## Schedule of updated planning drawings and reports following amendments to facilitate Ball Strike Netting and other minor alterations

DRAWING NUMBER : 22315-ALA-00-XX-DR-L-0022	STATUS : S2	REVISION : P04
--	-----------------------	--------------------------

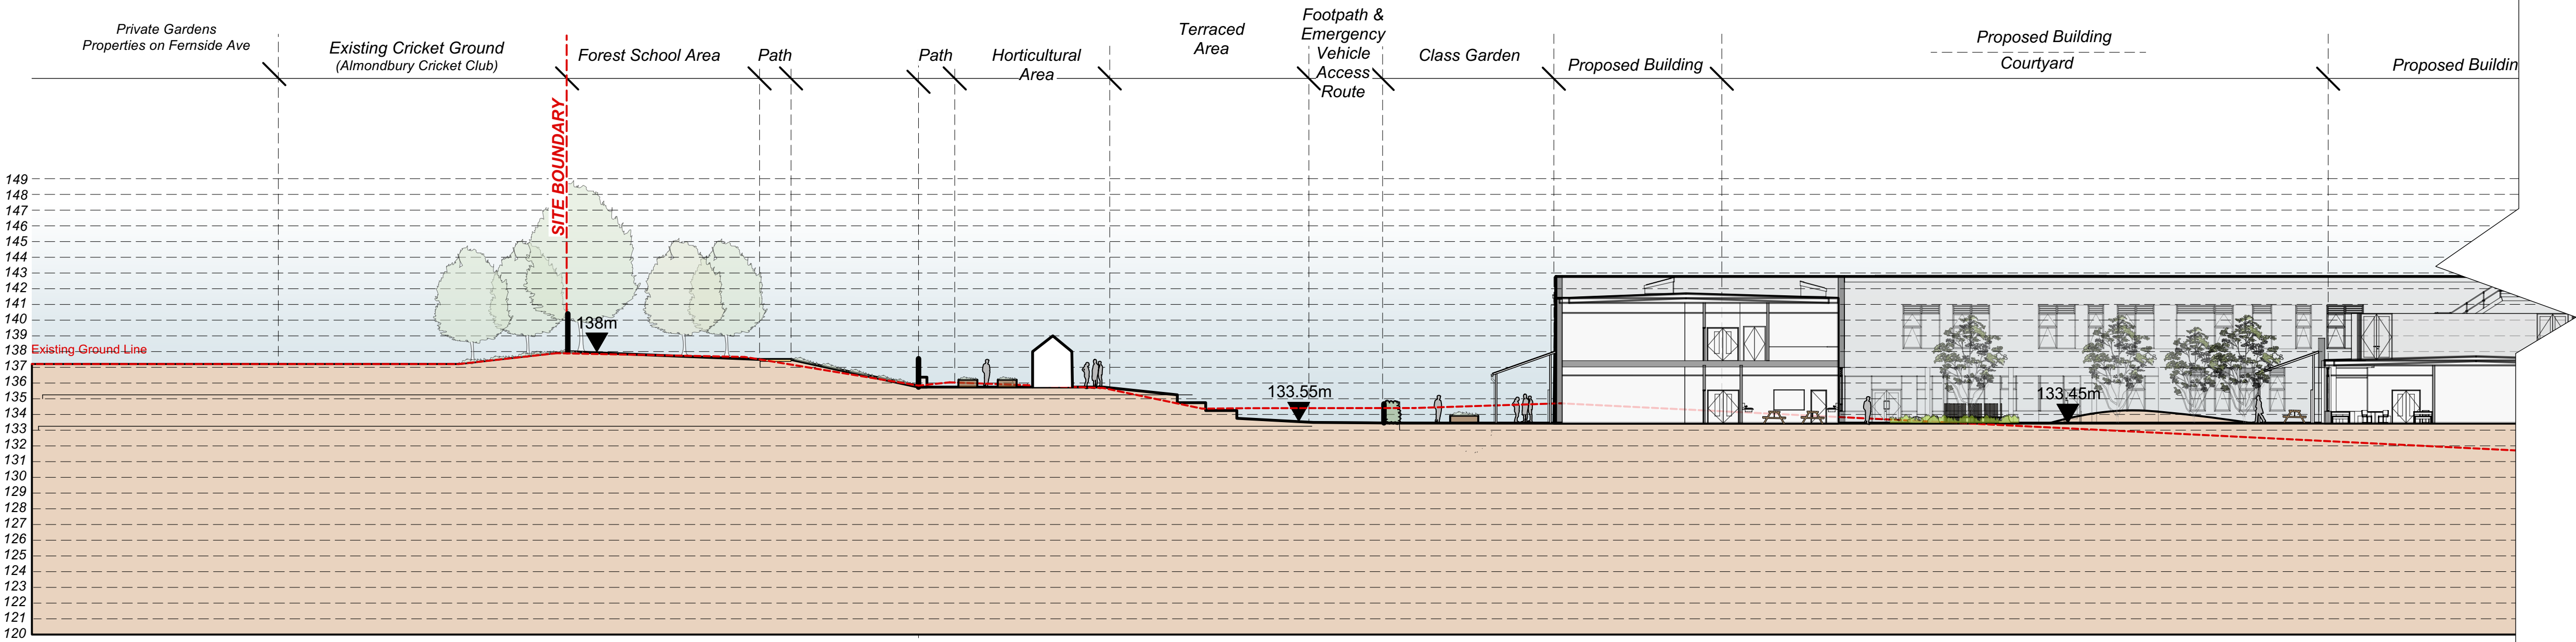
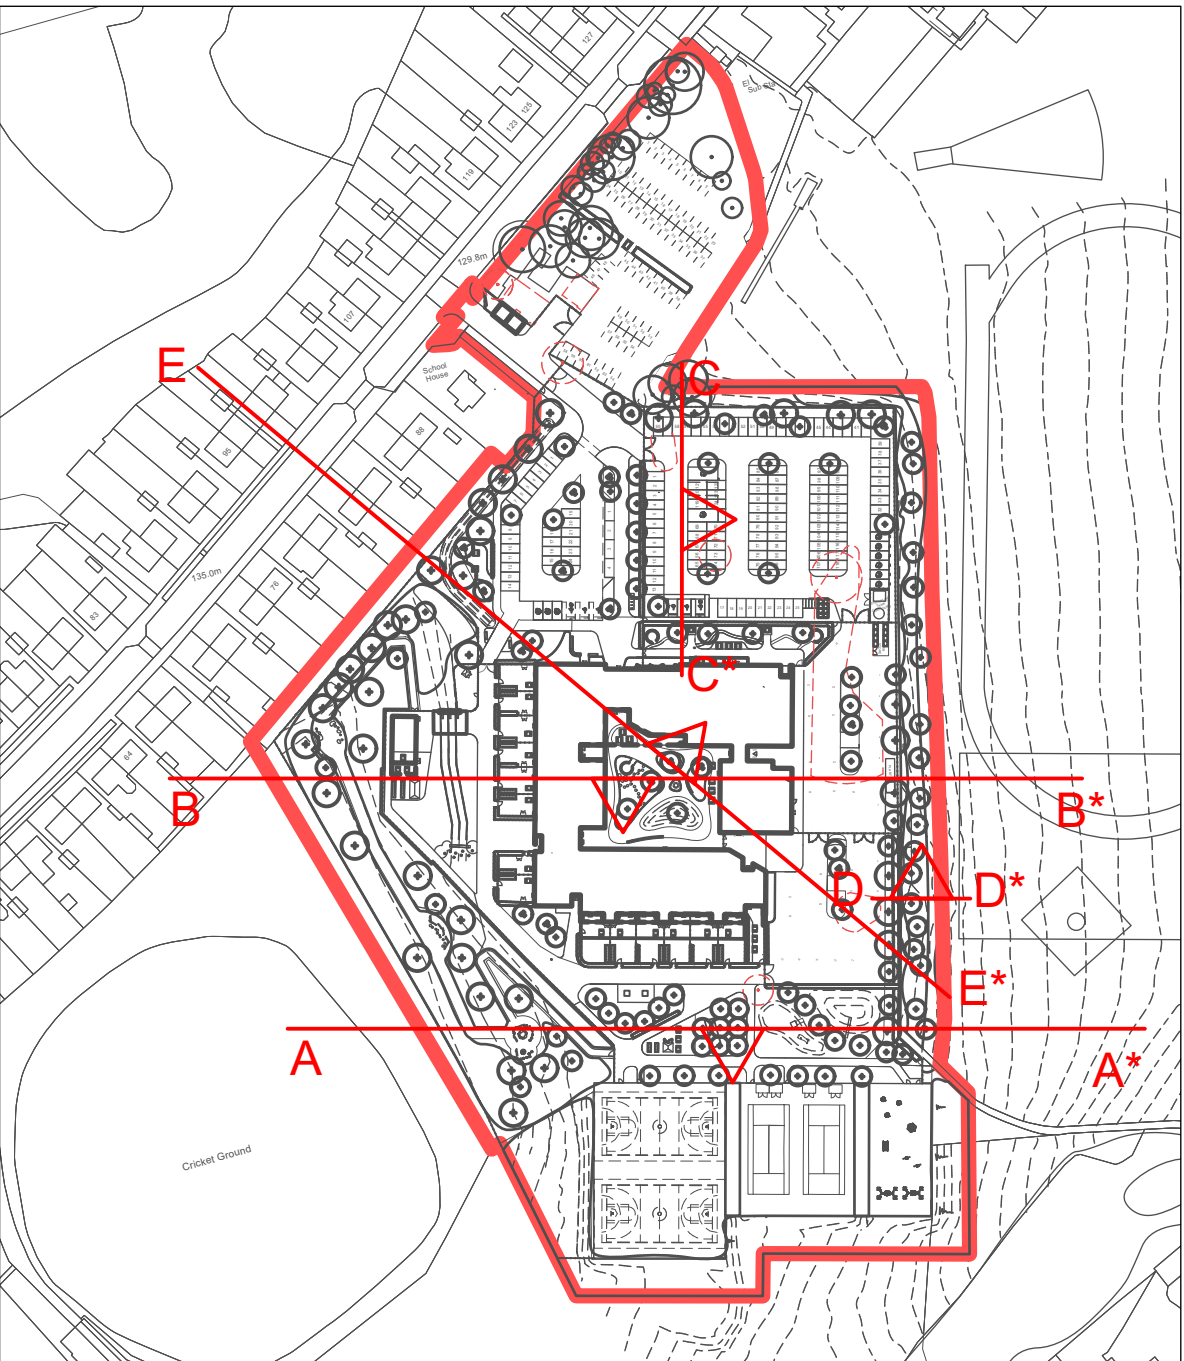
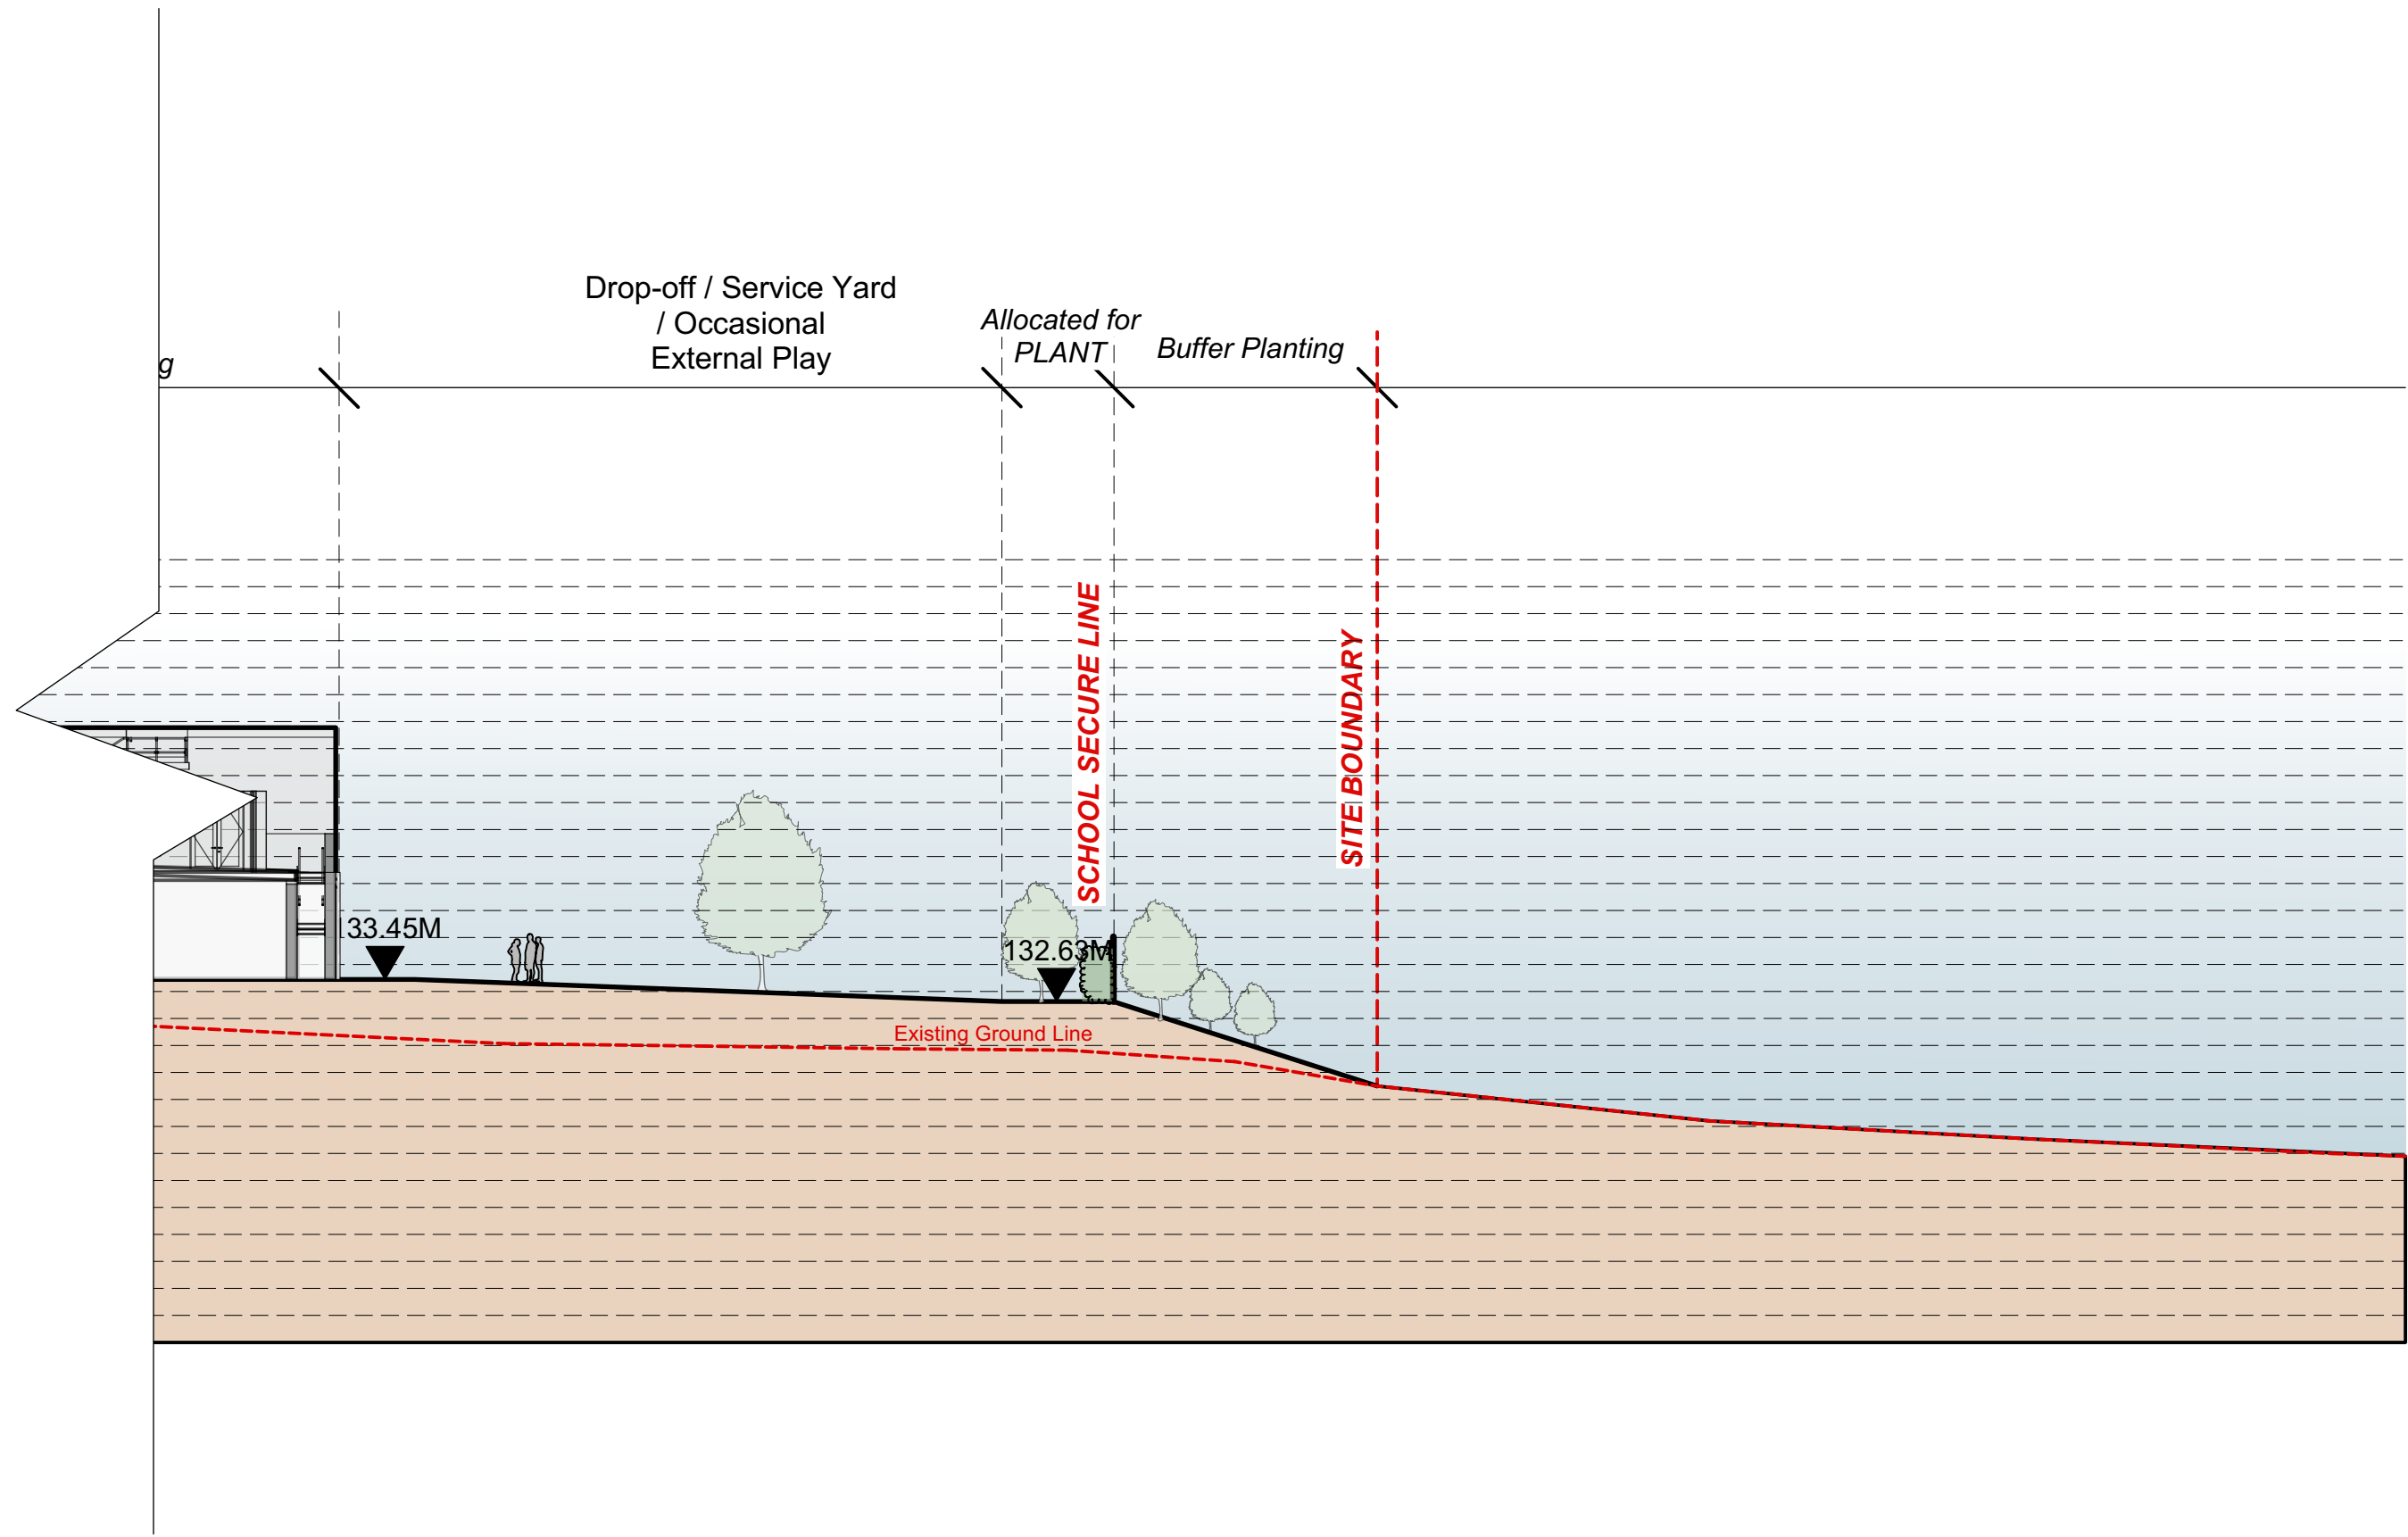
22315-ALA-00-XX-DR-L-0022 rev. P04	22315-ALA-00-XX-DR-L-0022 rev. P09	
	22315-ALA-00-XX-DR-L-0024 rev. P03	22315-ALA-00-XX-DR-L-0024 rev. P08	
	22315-ALA-00-XX-DR-L-0037 rev. P03	22315-ALA-00-XX-DR-L-0037 rev. P08	
Landscape Illustrative Masterplan	22315-ALA-00-XX-DR-L-0001 rev. P13	22315-ALA-00-XX-DR-L-0001 rev. P17	Re-issued for planning following Sport England objection withdrawal. Changes as follows: 1. Ball Stop netting added, hedge removed, and Forest School area updated. 2. Substation relocated and pedestrian entrance route. 3. Terracing and slide to Forest School amended.

DRAWING NUMBER :	STATUS :	REVISION :
22315-ALA-00-XX-DR-L-0010	S2	P02

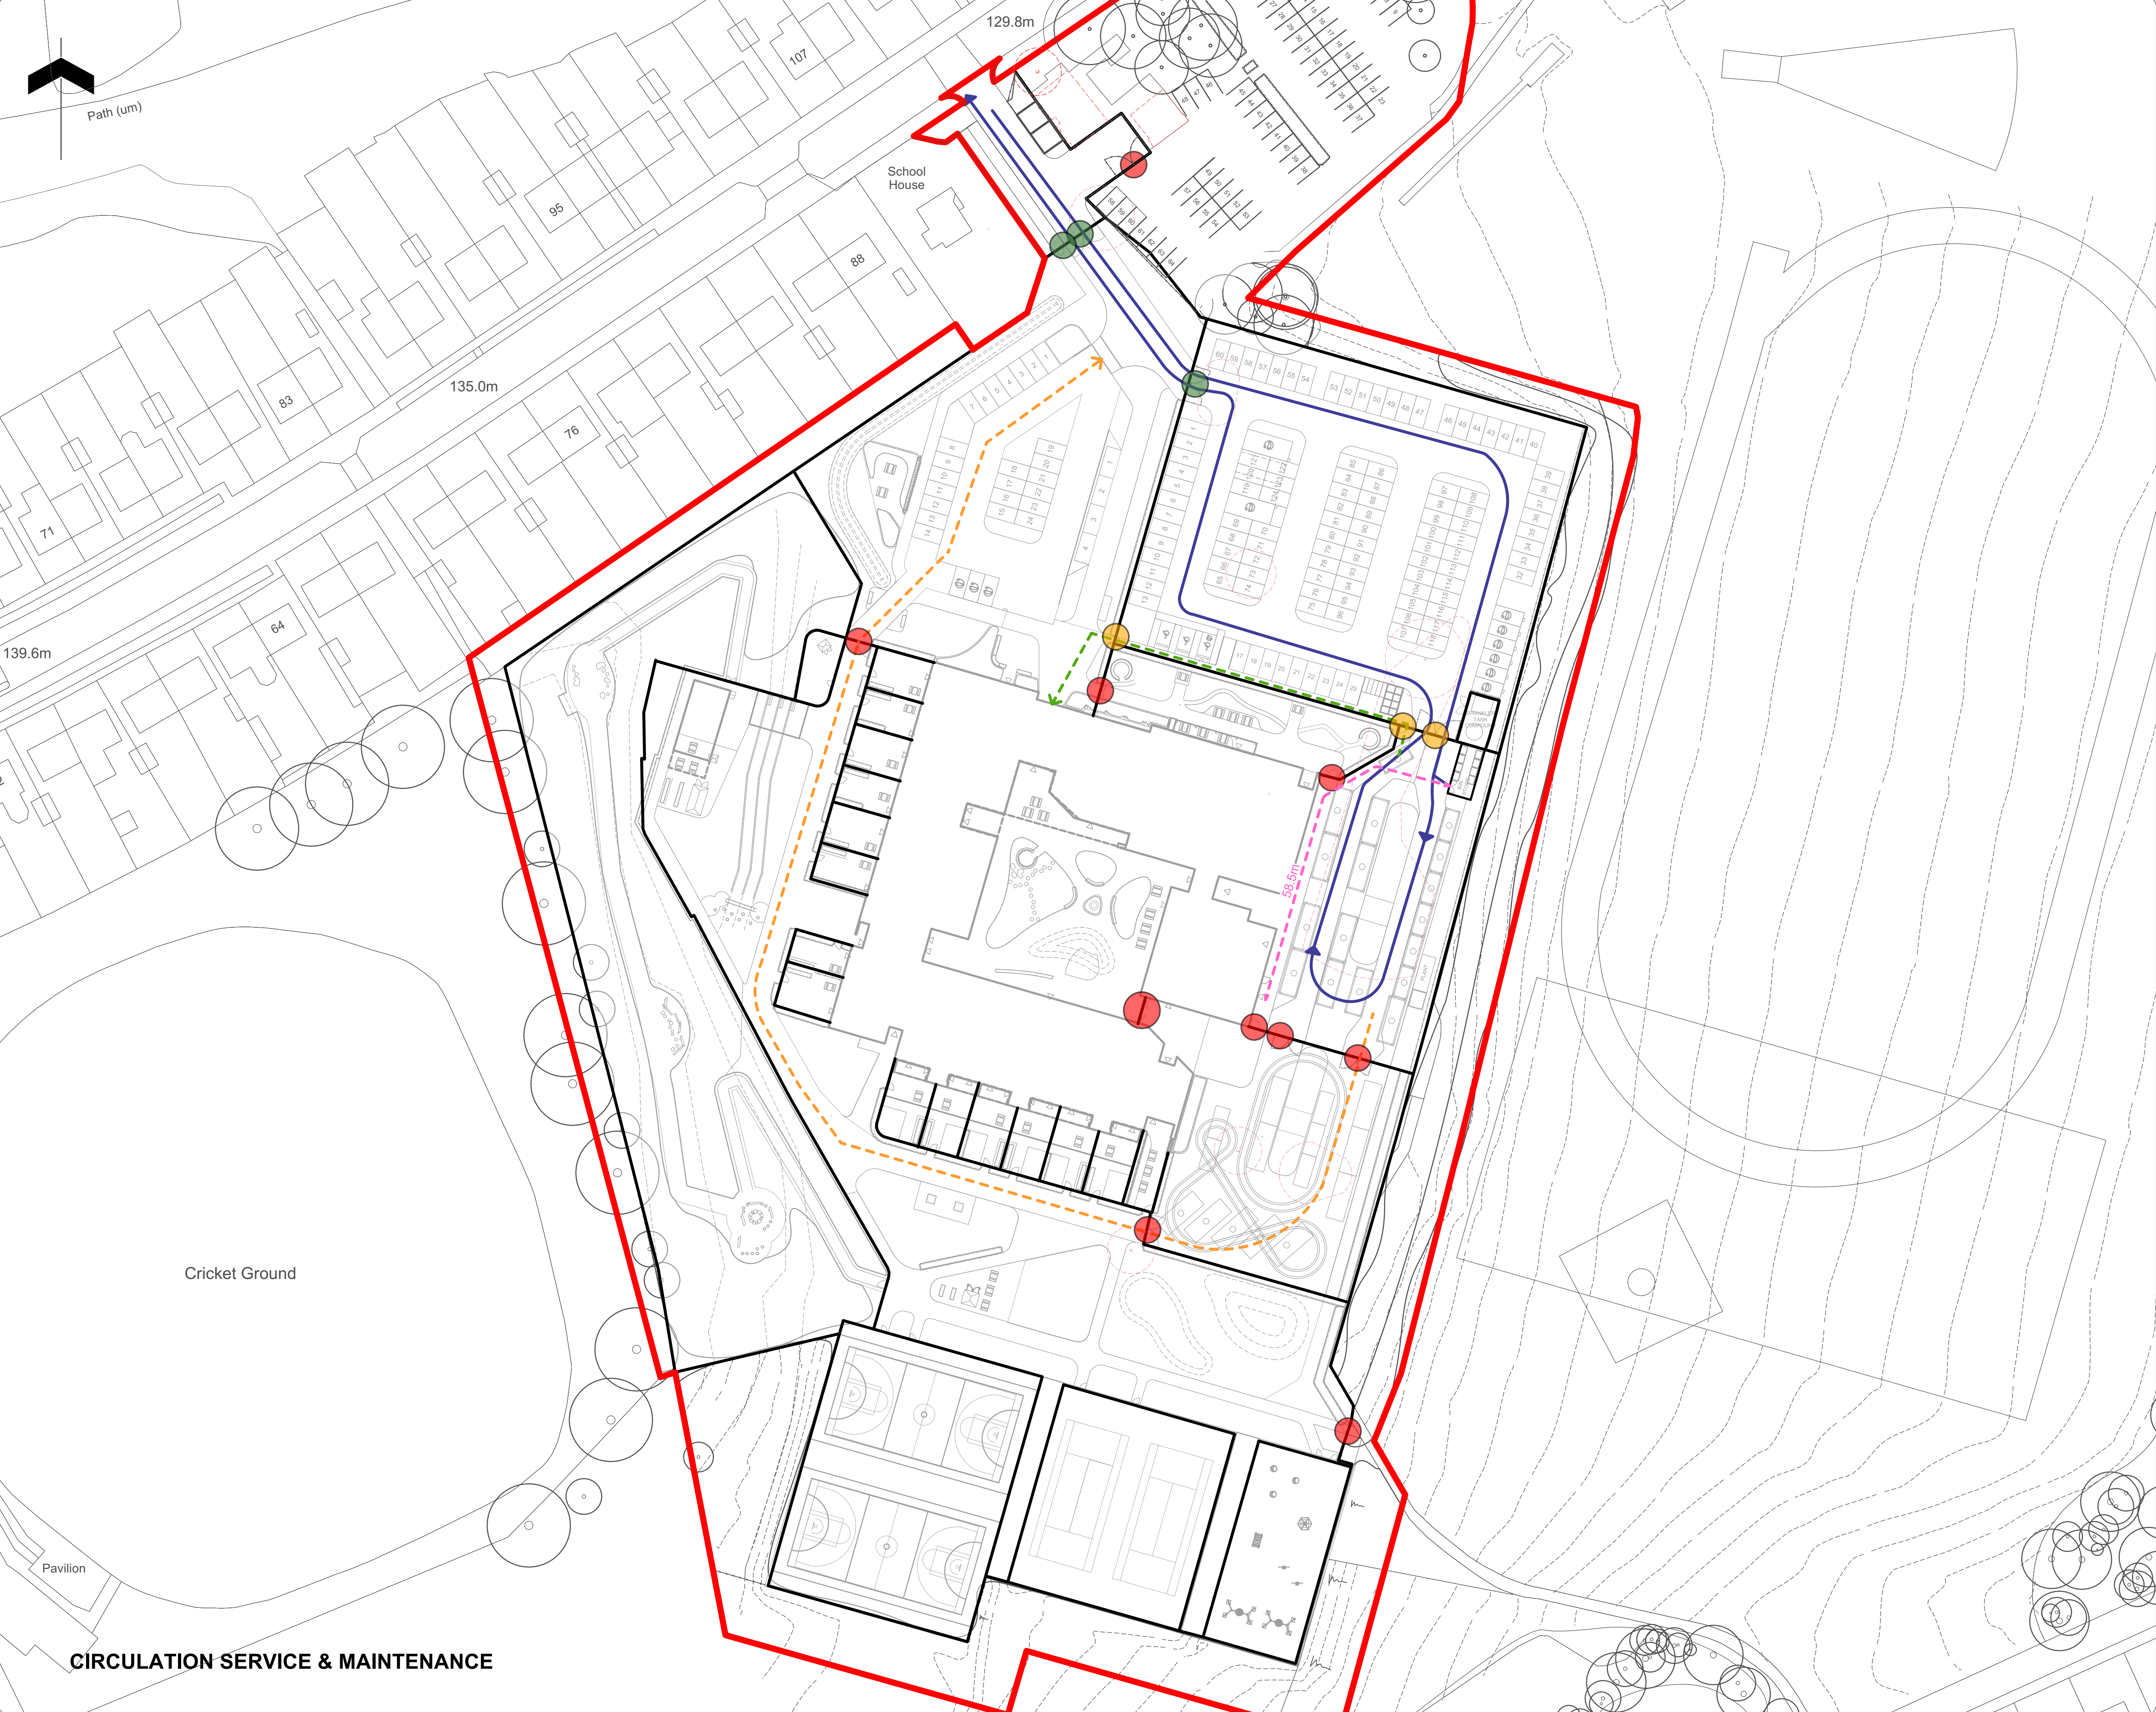
Access and Circulation Plans -Service and Maintenance -During the School Day -Arrival and Departure Students	22315-ALA-00-XX-DR-L-0010 rev. P02 22315-ALA-00-XX-DR-L-0012 rev. P02 22315-ALA-00-XX-DR-L-0021 rev. P03	22315-ALA-00-XX-DR-L-0010 rev. P04 22315-ALA-00-XX-DR-L-0012 rev. P04 22315-ALA-00-XX-DR-L-0021 rev. P05	Re-issued for planning following Sport England objection withdrawal. Changes as follows: 1. Updated to align with changes to GA. 2. Vehicle entrance barrier indicated on diagram.
EVCP Provision Plan	22315-ALA-00-XX-DR-L-0033 rev. P01	22315-ALA-00-XX-DR-L-0033 rev. P06	Re-issued for planning following Sport England objection withdrawal. Changes as follows: 1. Updated to align with changes to GA.
Waste Management Plan	22315-ALA-00-XX-DR-L-0034 rev. P01	22315-ALA-00-XX-DR-L-0034 rev. P06	Re-issued for planning following Sport England objection withdrawal. Changes as follows: 1. Updated to align with changes to GA.

Plan	Reference	Updated drawing	Description of amendments
			2.Binstore layout revised.
Urban Green Space	22315-ALA-00-XX-DR-L-0035 rev. P01	22315-ALA-00-XX-DR-L-0035 rev. P03	Re-issued for planning following Sport England objection withdrawal. Changes as follows: 1.Updated to align with changes to GA.
Sequential Axonometric	WSC-FSA-XX-XX-DR-A-7010 rev. P05	No revision	No revision
Street Scene Plan	WSC-FSA-XX-XX-DR-A-7020	No revision	No revision
Proposed Drainage Layout	22315-BWB-XX-XX-D-C-0500 rev. P03	No revision	No revision
External Lighting Plan	22315-AGL-24-XX-D-E-0001 rev. P06	No revision	No revision
Planning and Legal Completion Boundary Plan	22315-ALA-00-XX-DR-L-0038 P01	No revision	No revision
Ball Stop Netting Layout	22315-ALA-00-XX-DR-L-0049_P02	(previously submitted on 23.01.25)	Details of proposed ball stop netting to meet Sports England requirement
<b>New Plan</b> - Ball Stop Netting Detail	n/a	22315-ALA-ZZ-ZZ-D-L-1034_P03	Details of proposed ball stop netting to meet Sports England requirement
